**Consultation Response from KC,
Ecology Unit**

2026/92335 Upper Holme House Farm, Hirst Lane, Cumberworth, Huddersfield, HD8 8GA

Discharge of details reserved by conditions 6 (CEMP), 7 (lighting scheme), 8 (Tree Protection Plan), 9 (BEMP), 10 (WSI) on previous permission 2025/92605 for erection of stables and garage and formation of riding manege

Date Responded: 01/09/2026

Figure 3.1 Site proposals plan of new and enhanced habitats on-site

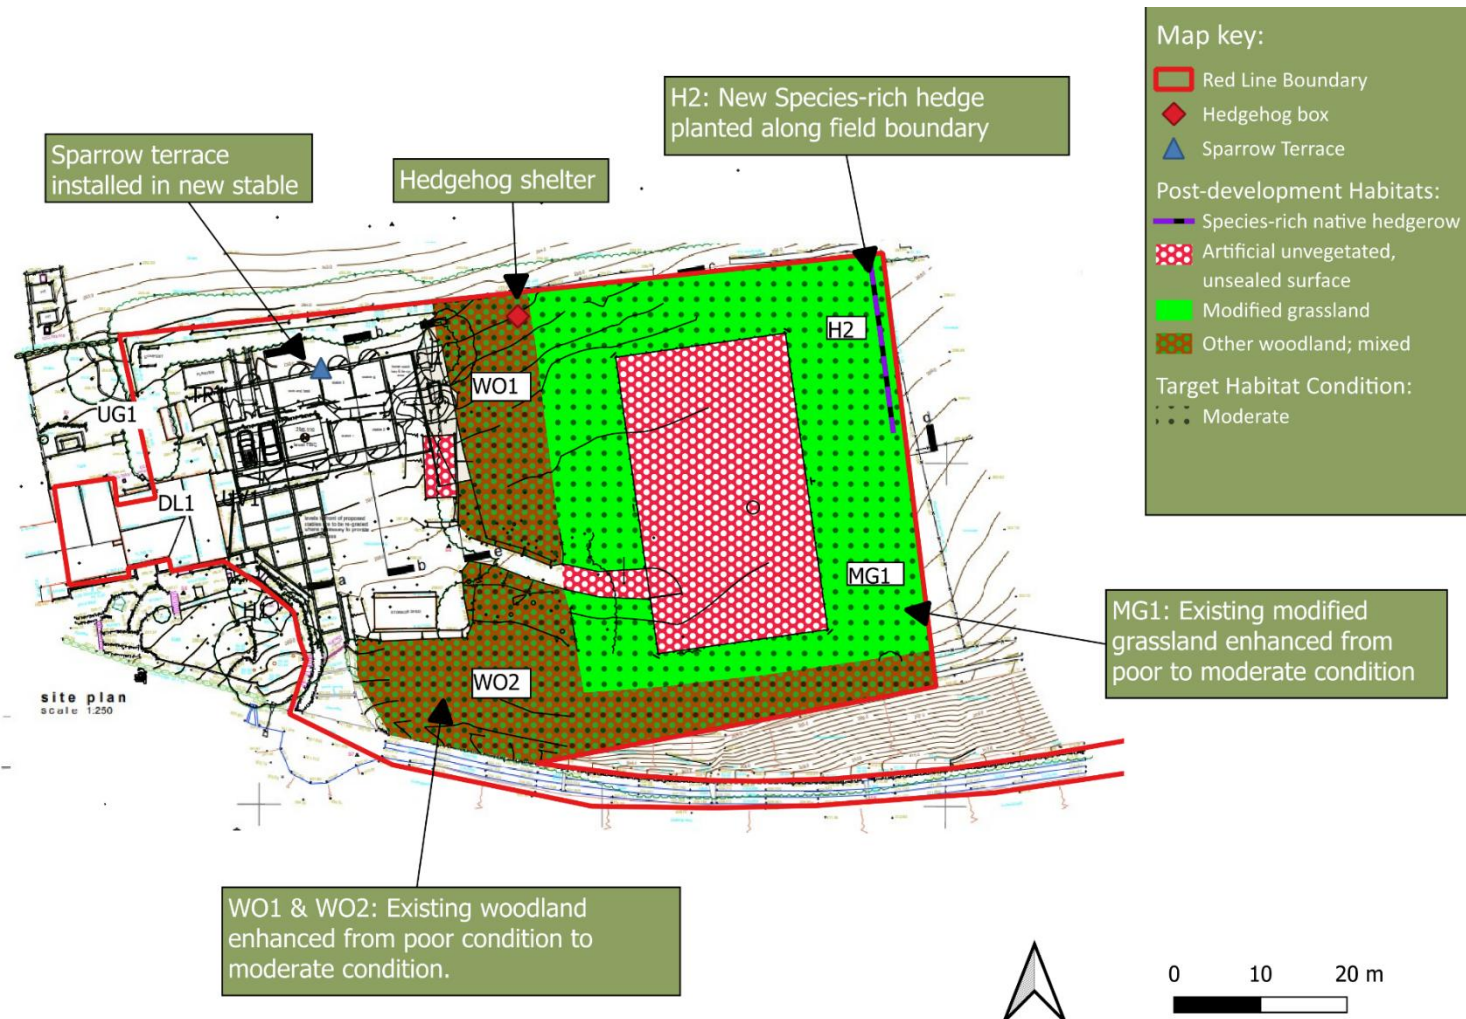
The Biodiversity Enhancement Management Plan (Woodsage Consulting, March 2026) identifies a sparrow terrace will be installed in the new stable block, and a species rich hedgerow will be planted along the eastern boundary. The existing woodland will be enhanced to moderate condition through targeting thinning and retaining the felled trees as deadwood. The grassland surrounding the menage will be enhanced through sowing an appropriate native species mix and limiting the horse grazing intensity. No new fences are proposed which will not be permeable to wildlife. I am therefore satisfied that Condition 9 can be discharged.

Design Ref:	LS4071603	Revision(s) From Previous Design:
Design By:	Millie Webster	
Date: 17/02/2026	Scale: 1:250 @ A2

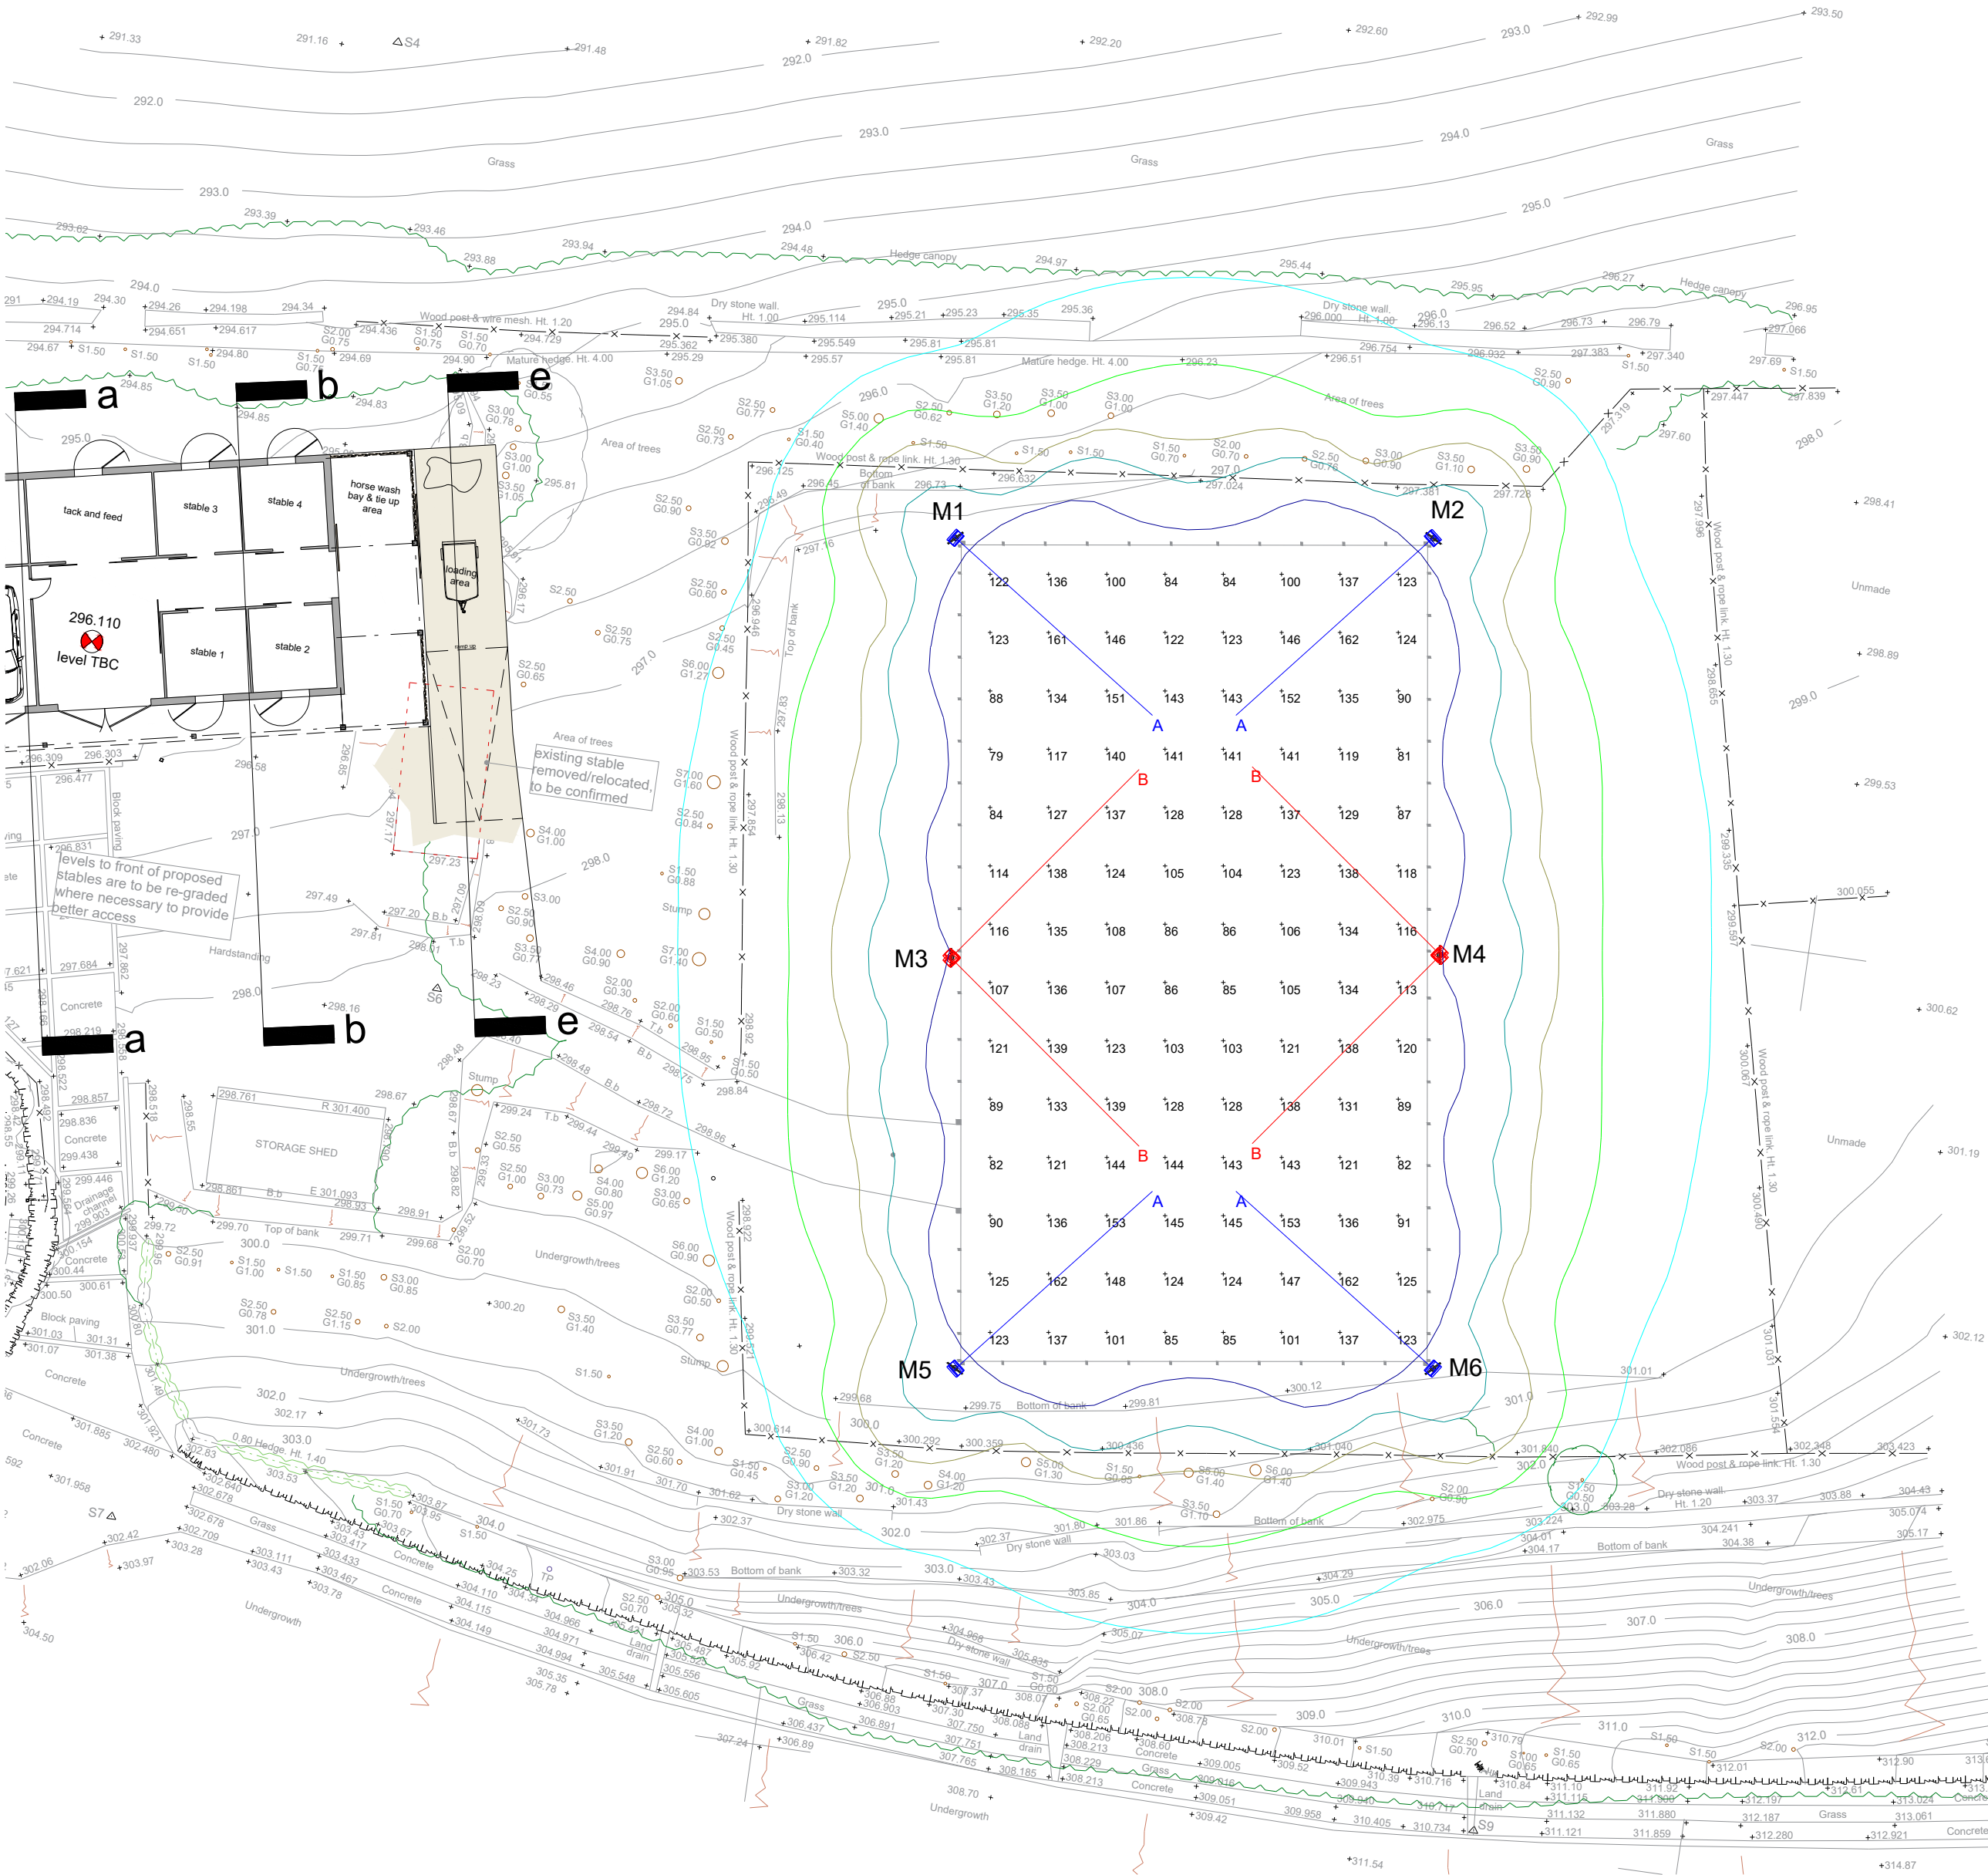
The submitted lighting plan shows that areas of vegetation, identified as part of the Kirklees Wildlife Habitat Network will be illuminated at ≤ 5 lux. Research has shown that many nocturnal species will avoid areas which are illuminated at this level, and therefore when the lights are on, parts of this wildlife network will be disconnected. The adjacent Local Wildlife Sites are not shown on the lighting plan, and it is therefore not possible to identify what the illumination impacts on these would be. I would recommend that the proposed lighting is further investigated, to see if measures such as altering the height, or rear shielding, could be implemented to ensure that the areas which are sensitive to wildlife are not illuminated > 1 lux.

Figure 4.1 Overview of Biodiversity Protection Zones including retained habitats, local wildlife sites and site boundary.

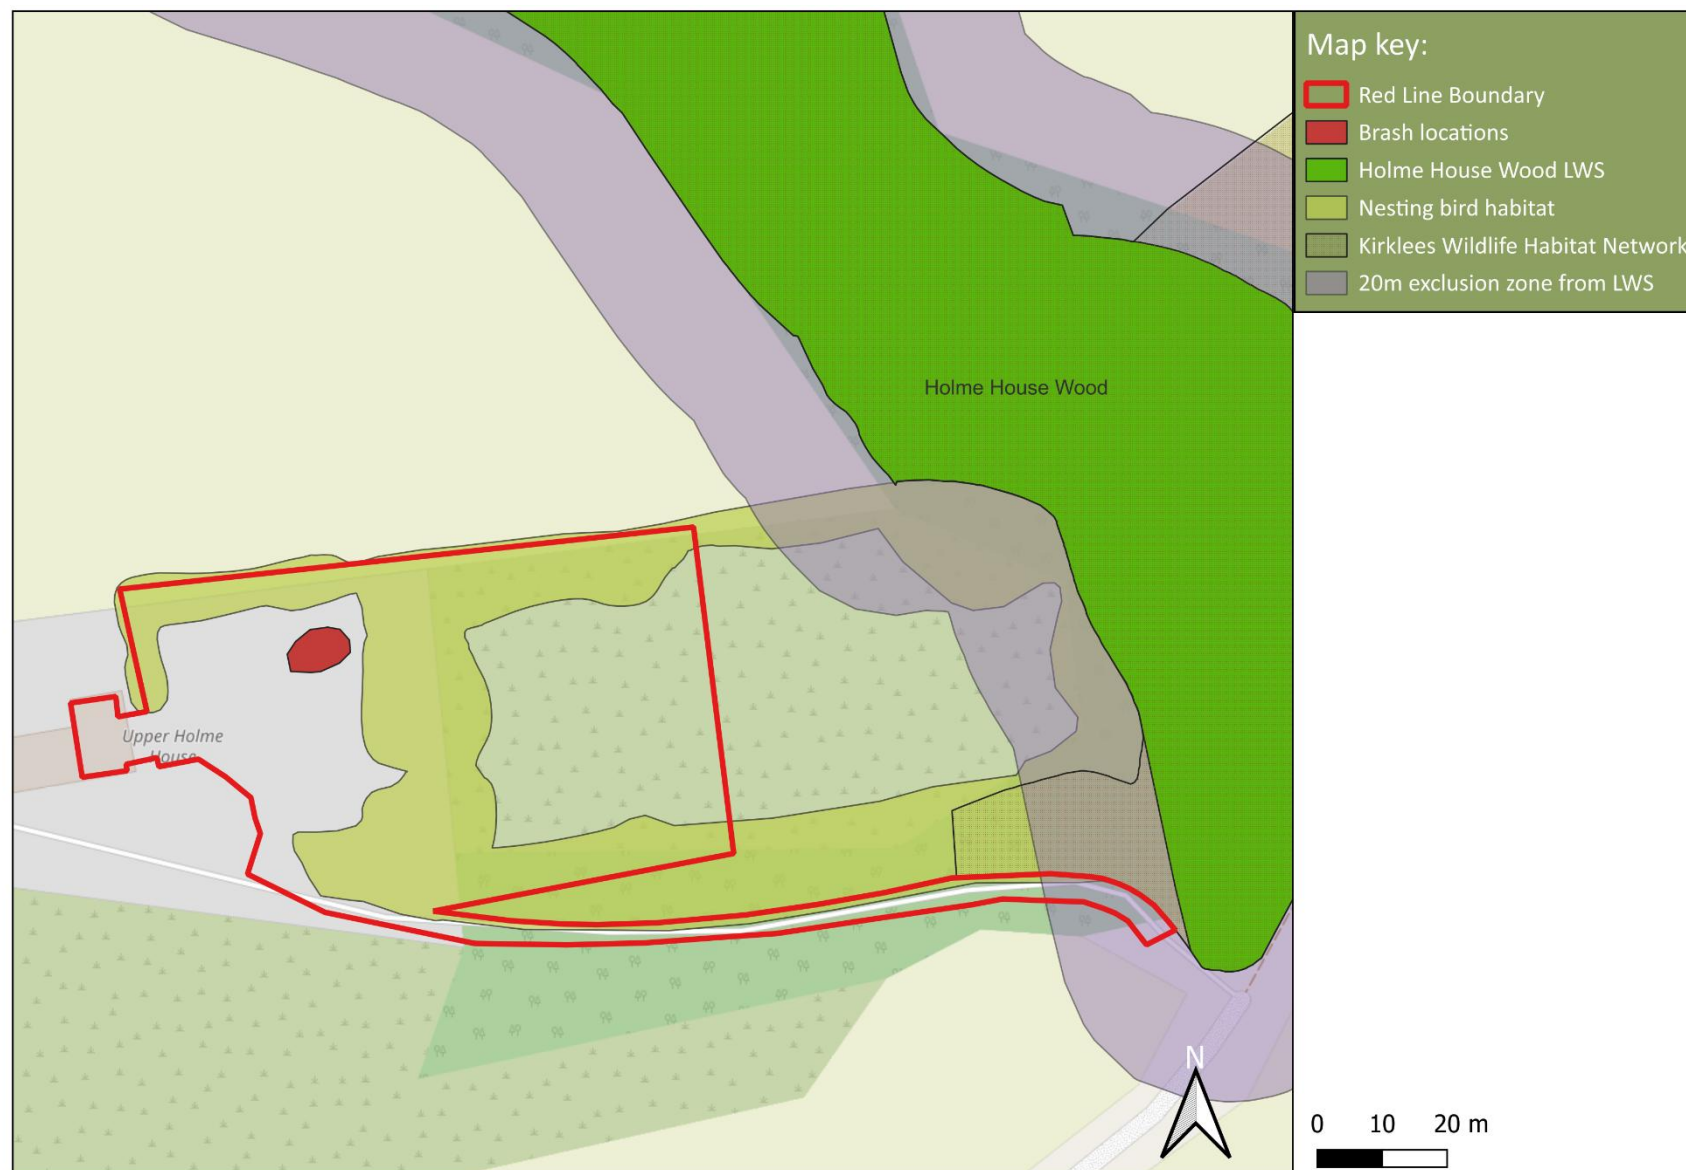
The Construction Environmental Management Plan (Woodsage Consulting, March 2026) identifies the key ecological constraints associated with the development, including vegetation removal, excavation works, construction lighting, and potential impacts on protected species. Biodiversity Protection Zones are defined around Holme House Wood Local Wildlife Site (LWS), the Kirklees Wildlife Habitat Network, and retained habitats. The report sets out practical mitigation measures to minimise the impacts of the construction on species such as hedgehogs, and works are timed to avoid the breeding bird season, or a pre-commencement breeding bird check will be undertaken. The plan identifies when specialist ecological oversight is required, namely for nesting bird surveys and hedgehog checks, and establishes clear responsibilities and lines of communication. Specific mitigation is provided for Holme House Wood LWS through lighting restrictions, buffer distances and habitat protection measures. I am therefore satisfied with the information provided and Condition 6 can be discharged.
